Objection to planning Application Number 2019/91141

We would like to raise an objection in relation to the proposed single dwelling on land adjacent to 320, New Hey Road, Oakes, Huddersfield, HD3 4GQ; 2019/60/91141/W. We appreciate the application is an Outline Application, however based on the information provided, we have the following comments;

STREET ELEVATION FROM
NEW HEY ROAD

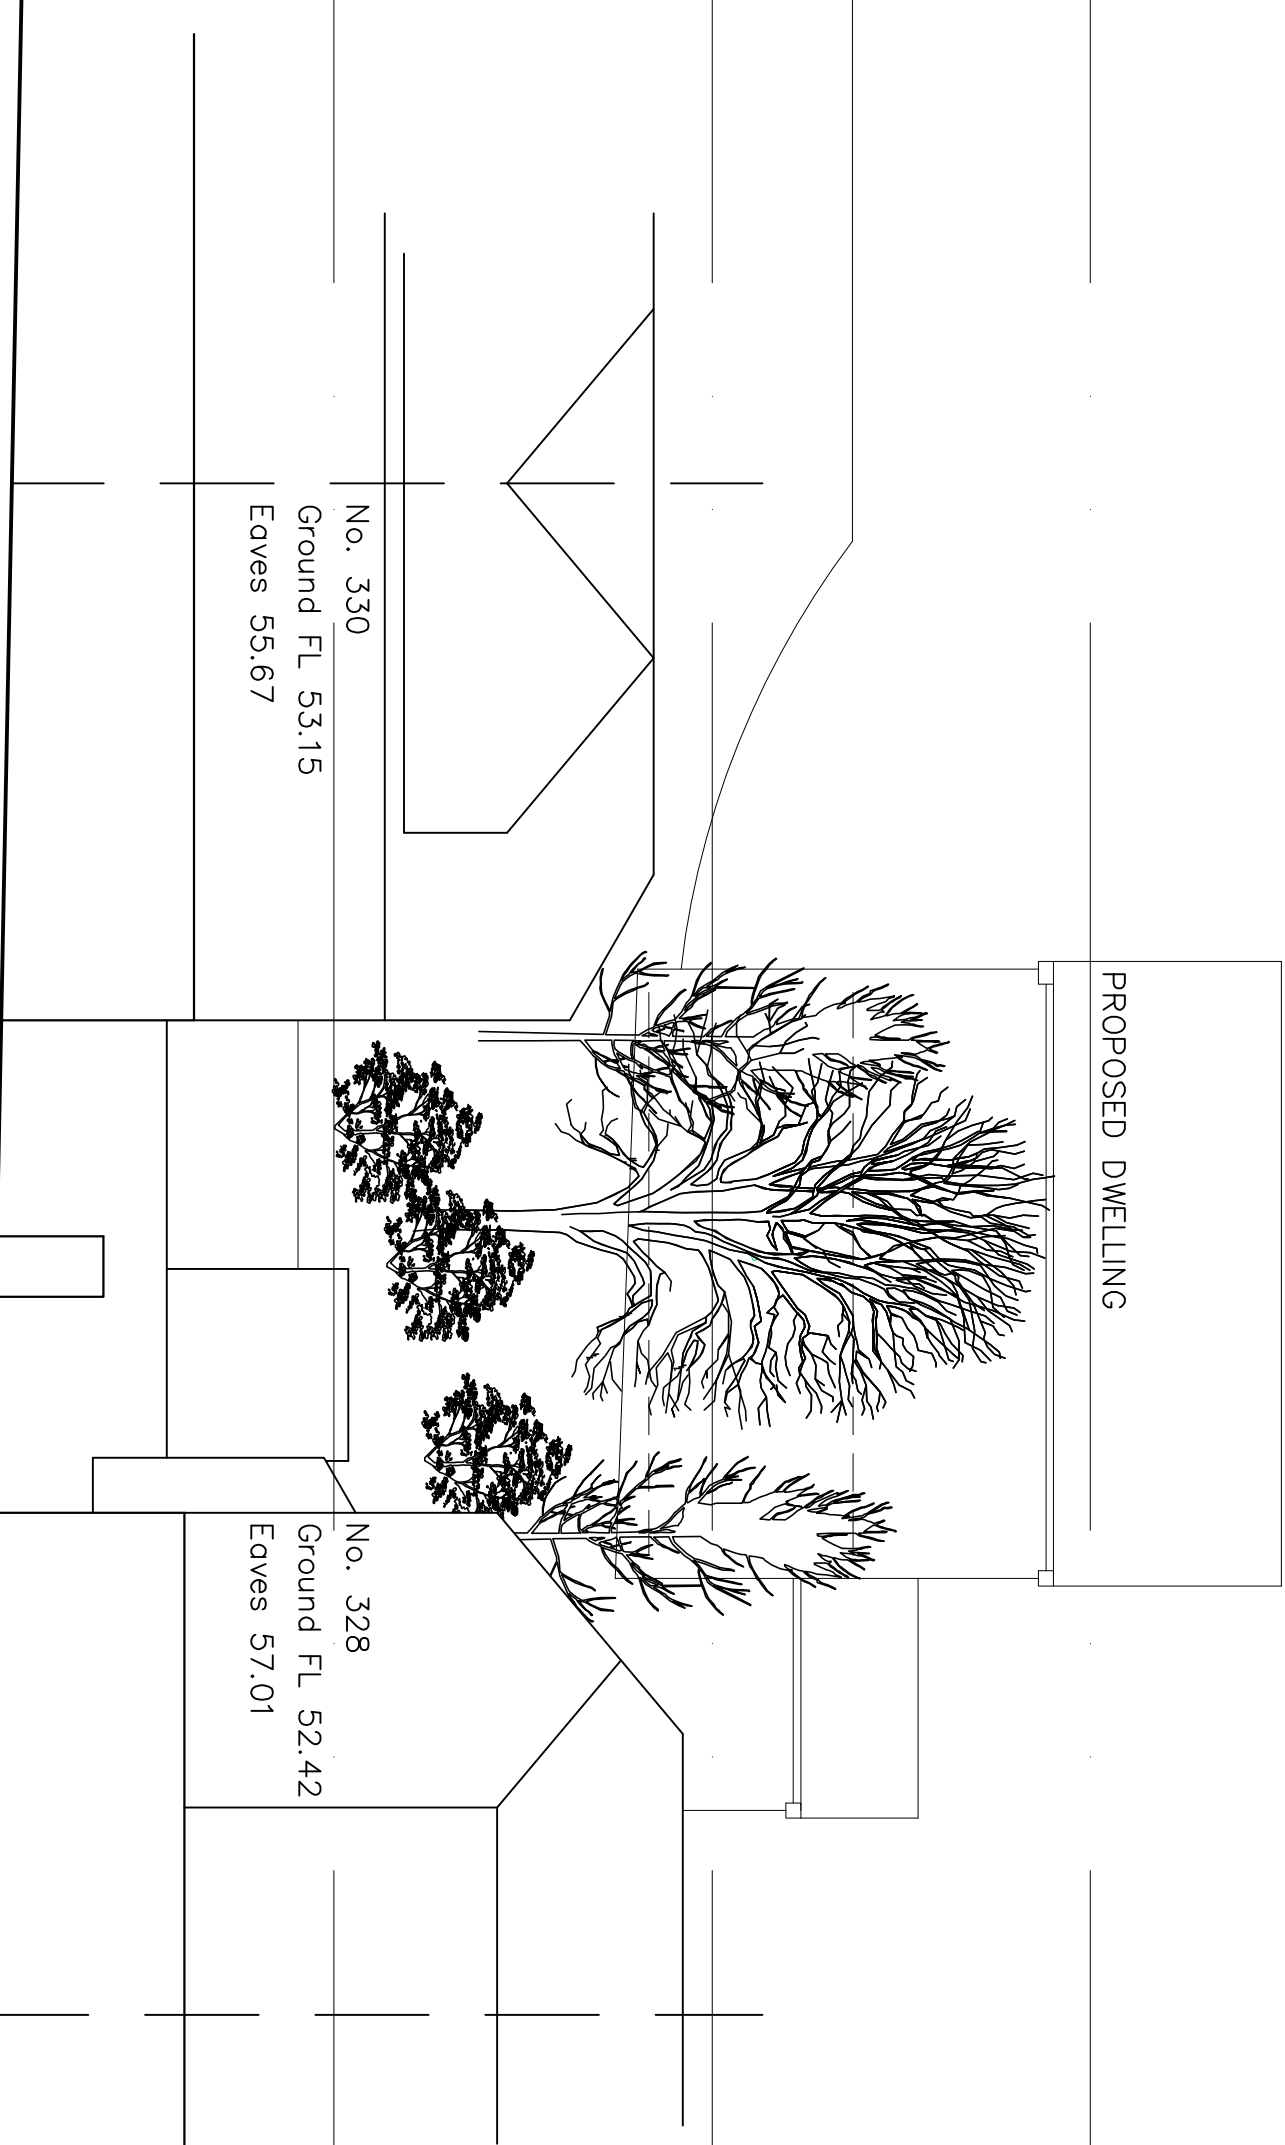
Notwithstanding the points above, we have the following objections. We have had to base some of these objections on assumptions due to the nature of information presented. We note the dimensions on the proposed scale drawing and have cross referenced this with the previous application street scene drawing. While we note there are no windows

presented at this time,
one would assume there will be habitable rooms to the first floor. If any of these were to have a window facing South or East a total and utter loss of any and all privacy to the adjacent properties would occur,
even considering the surviving trees and potential boundary fences where present. Due to the proximity and steep topographical position the dwelling would present as an overbearing dwelling with significant impact
on the remaining private amenity space of immediate properties to the East and South.

In summary, we feel a two storey dwelling would have a significant and lasting detrimental effect on the immediate surrounding dwellings and their occupants now and in the future, Considering the existing topography
we also believe the scale to be inappropriate creating an overbearing and dominant building overlooking everyone to the South and East. Removal of trees and issues with excessive surface water run-off will be exacerbated
increasing the likelihood of surface water flooding and damage to property. We believe the proposals are detrimental to the immediate built environment and the open nature of the street scene.

SITE PLAN

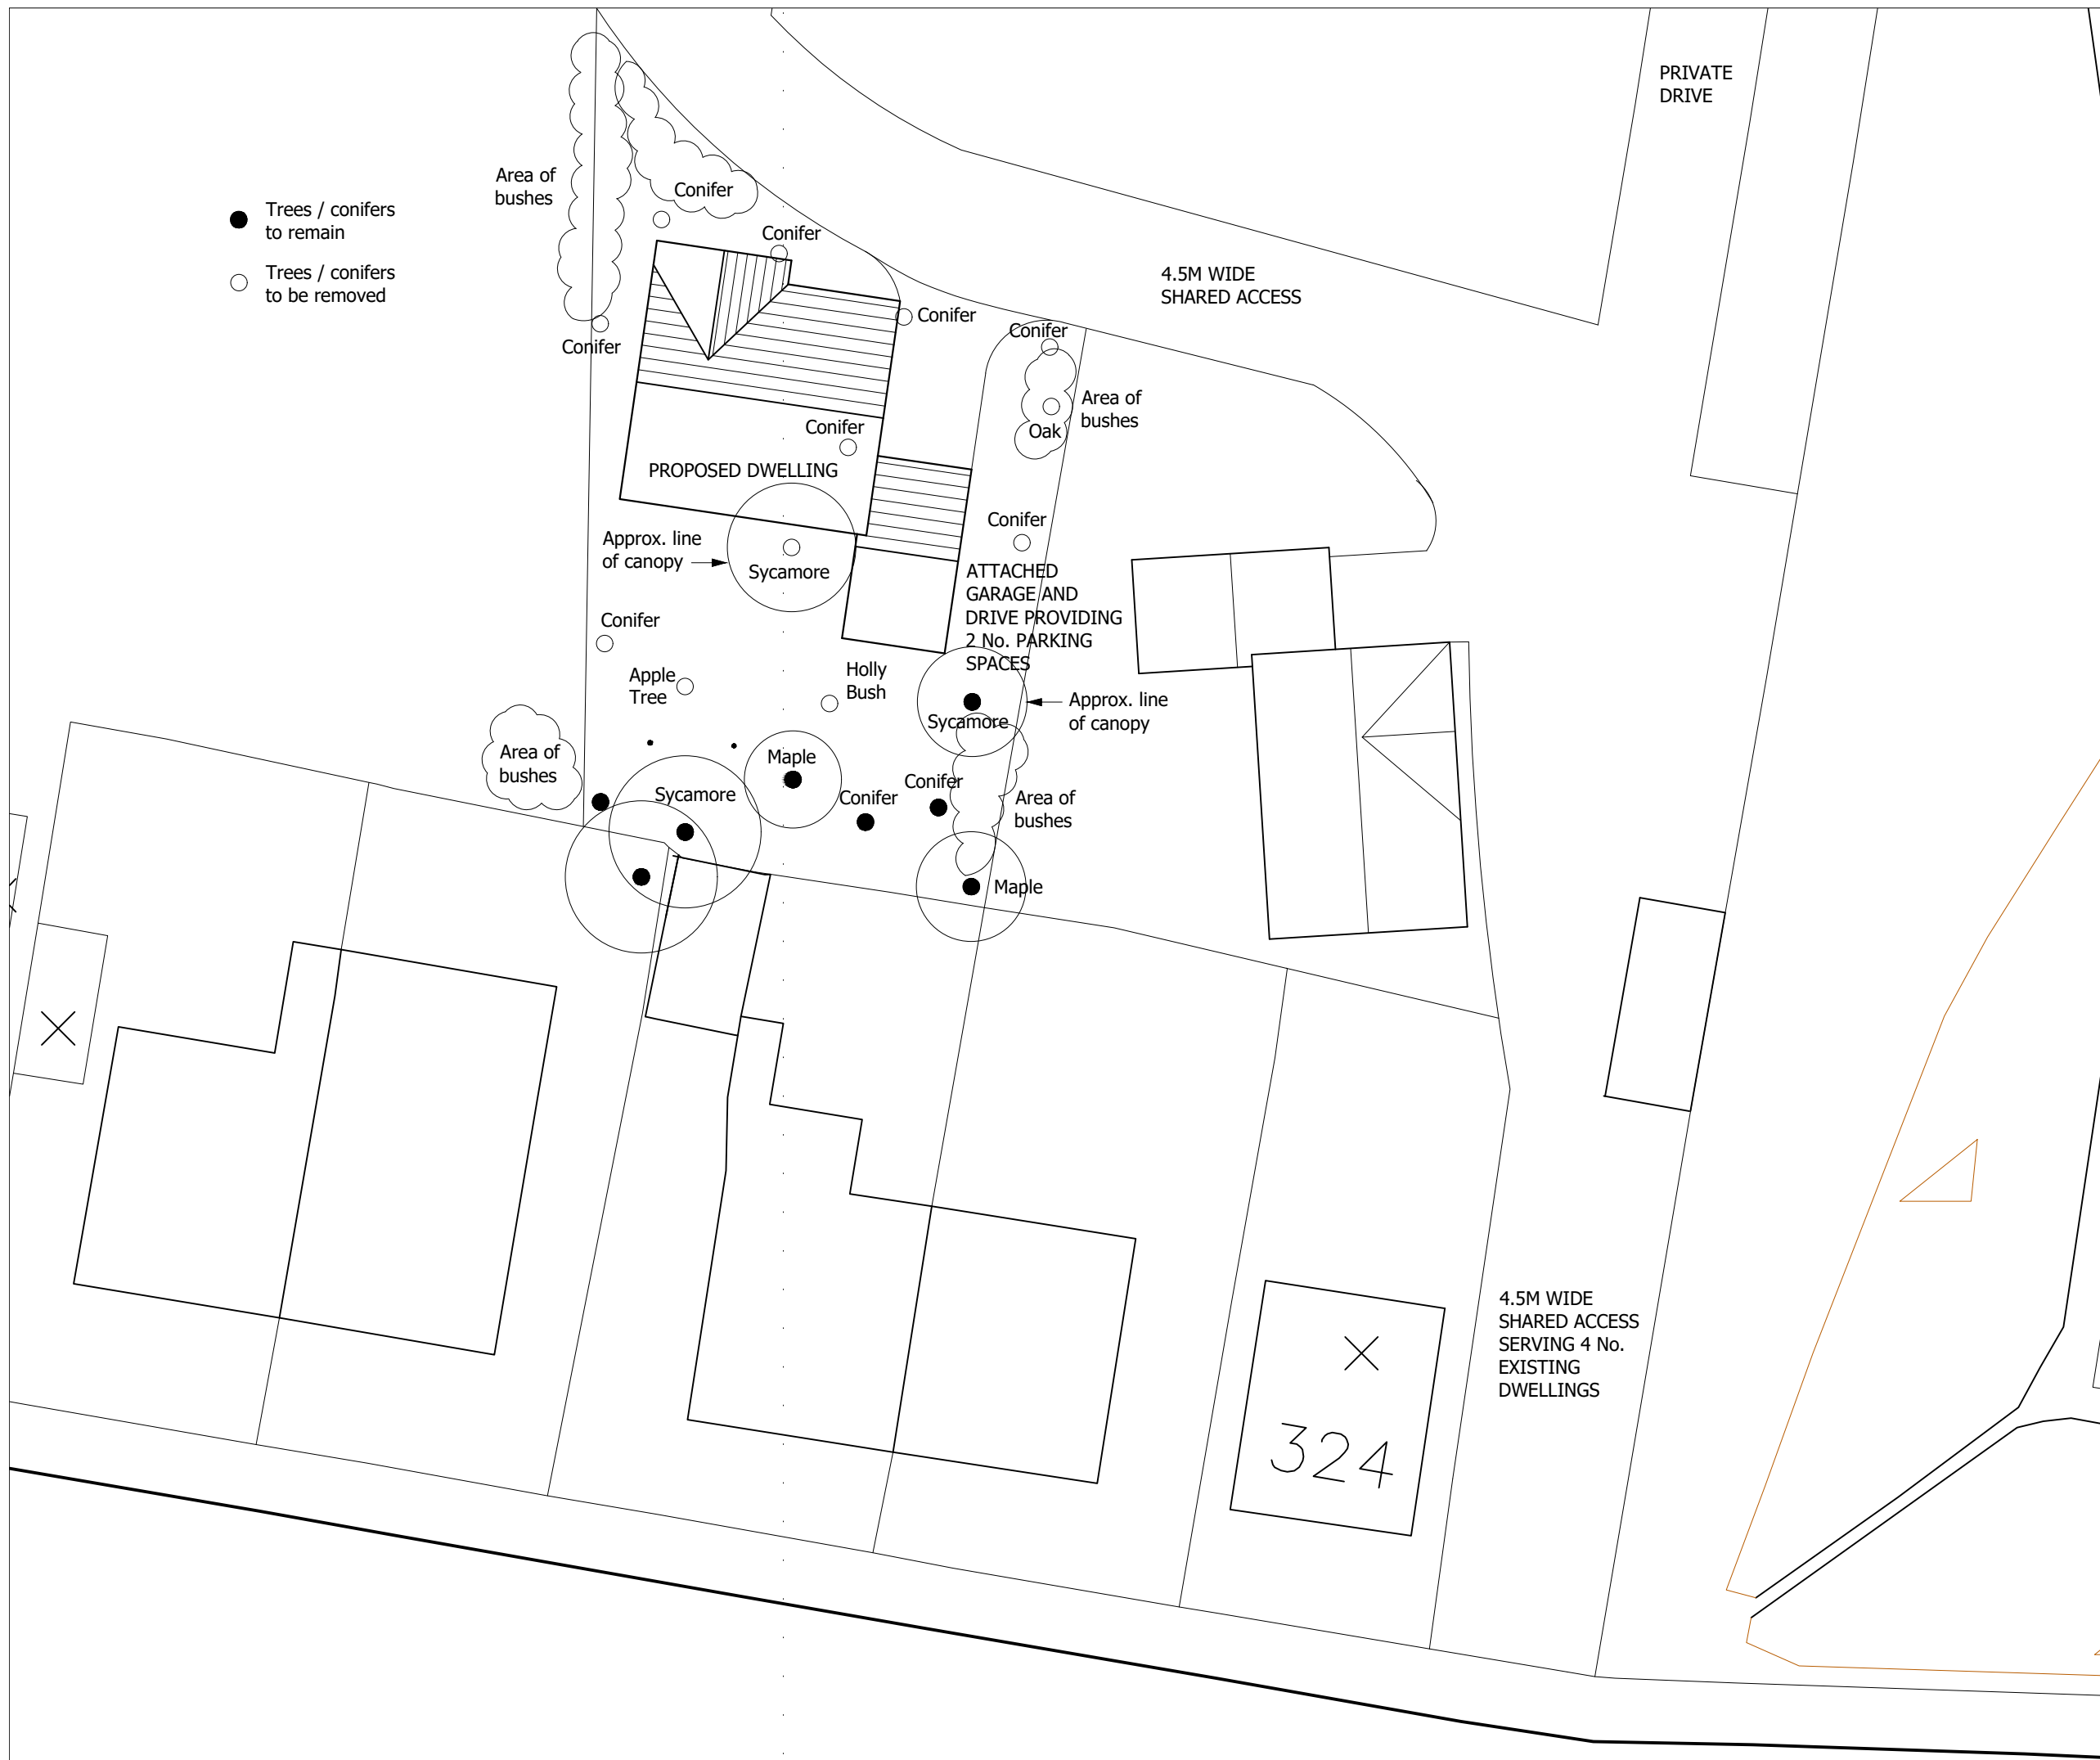
The proposed site block plan is inadequately drawn with no North arrow and demonstrates some obvious anomalies which would have bearing on any proposed dwelling;

The House to the assumed East of the proposed dwelling is orientated at an angle and is not parallel to the bungalows to New Hey Road as shown reducing the actual amenity space this property enjoys, this reduced size space will now assumingly be overlooked and lose significant private space.

The proposed block plan shows the trees in locations that do not correspond with the locations on site, giving a false representation of where the house might finally be sited.

House number 330 has an extension to the rear which accommodates a dining and kitchen area (habitable room) which is closer to the proposed dwelling than is currently indicated. We have measured this, and it would be no further away than 15.617 Metres if the block plan is drawn accurately. Please see attached drawing.

Worryingly the ordinance survey is out of date some revisions are dated 2008, with no license reference. I assume this plan has been reused from the previous applications and is supplied without the license reference being shown breaching the requirements of Kirklees council and copyright laws.
